**WEST SUSSEX COUNTY COUNCIL
STRATEGIC PLANNING CONSULTATION**

SUBJECT: Premier Inn – Spinney and Burberry House

Roundstone Lane/ Roundstone Road, East Preston, Angmering, BN16 1EB

RECOMMENDATION:

PROPOSED SITE PLAN

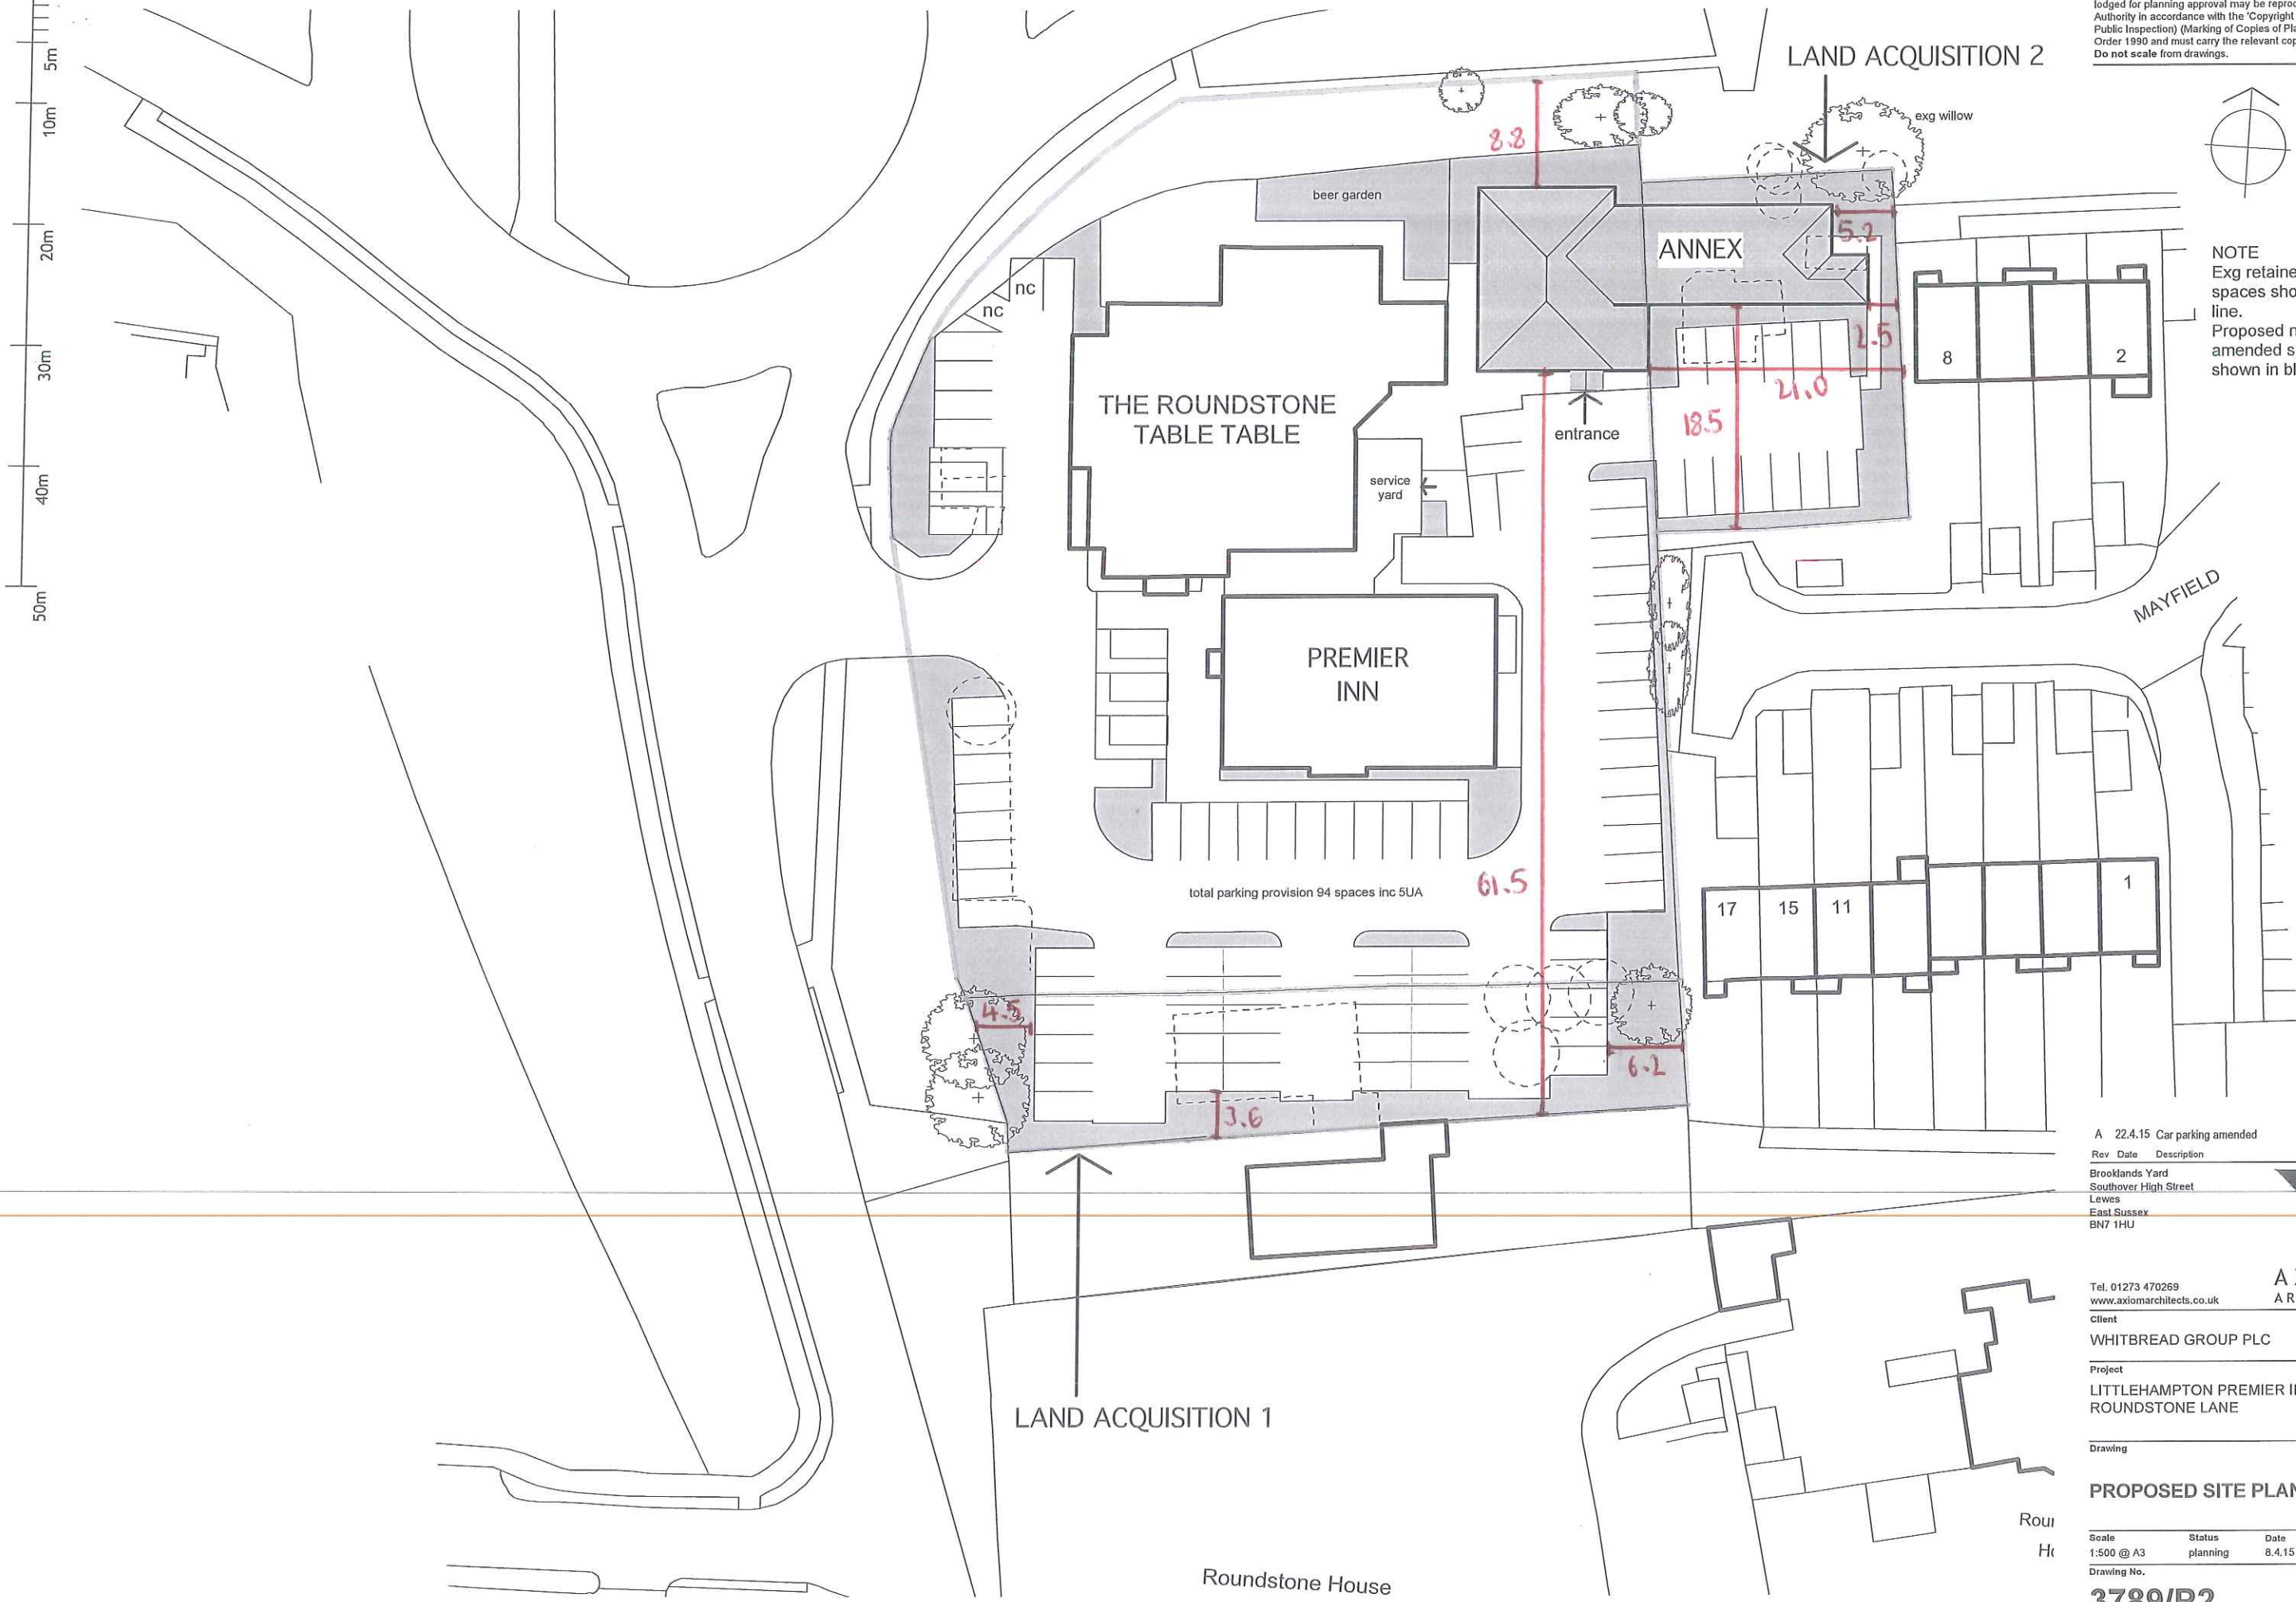
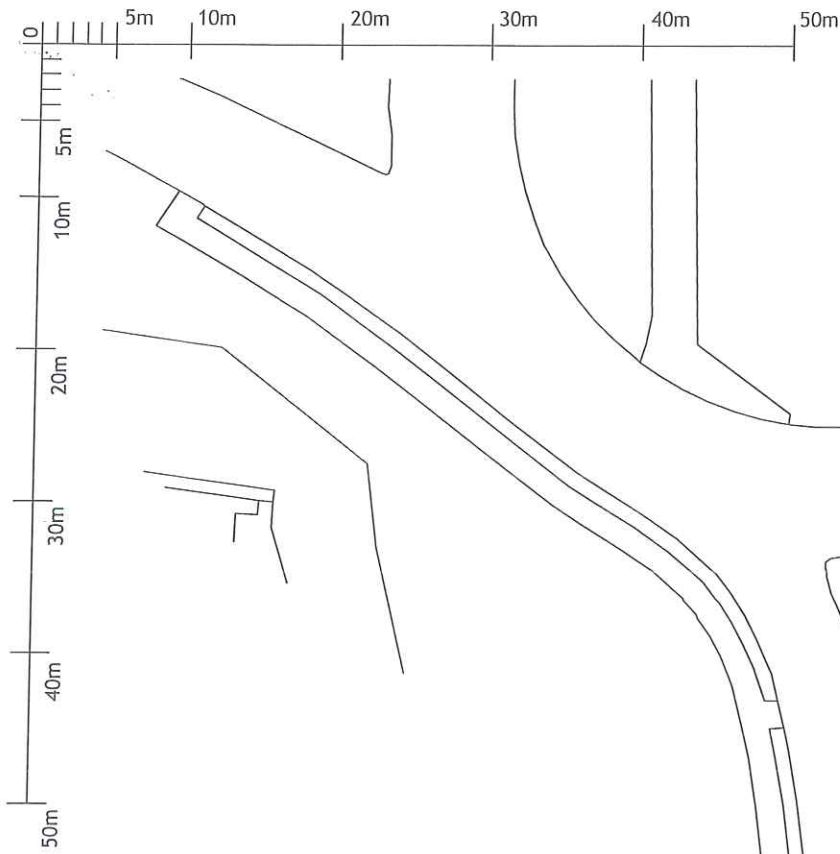
Land for the new annexe building and additional car parking has been acquired by demolishing the neighbouring properties of Spinney and Burberry. Both are residential properties with existing access points onto the highway network. Spinneys access is shared with another property and will remain in use however; Burreberrys access onto the A529 Roundstone Road will need to be closed. This can be controlled via a suitably worded planning condition, and progressed via the S278 process.

The site will provide additional parking. This has been checked and is in line with WSCC car parking standards for restaurants and hotels. The standards indicate that for the size and type of development, 1 space per bedroom and 1 space per table should be adopted. This would equate to 40 spaces for the bedrooms and 44 spaces for the restaurant, creating a total of 84 spaces. The proposals indicate the site will be able to offer 92 car parking spaces, well within the maximum standards recommended. Indeed, the supporting parking surveys show that it is unlikely the car park will ever reach full capacity. This is due to the complimentary nature of both businesses whereby the car park can be used at different times of the day without conflict. The parking surveys show that at its busiest the car park was only 55% occupied.

Cycle parking, which is covered and secure, will need to be provided in line with WSCC cycle parking guidance for half a space per bedroom or similar to what has been implemented at other Premier Inn locations.

Details of the demolition/construction phase of the development have not been submitted and will need to include details as per the recommended condition below. In particular WSCC would consider keeping the works traffic and customer traffic separate for the duration of the build, and this must be submitted prior to any commencement of building works.

No part of the development shall be first occupied until such time as the existing vehicular access onto A259 Roundstone Road has been physically closed in accordance with plans and details submitted to and approved in writing by the Local Planning Authority.

Car parking space (details required)

No part of the development shall be first occupied until the car parking spaces have been constructed in accordance with plans and details submitted to and approved in writing by the

No part of the development shall be first occupied until covered and secure cycle parking spaces have been provided in accordance with plans and details submitted to and approved by the Local Planning Authority.
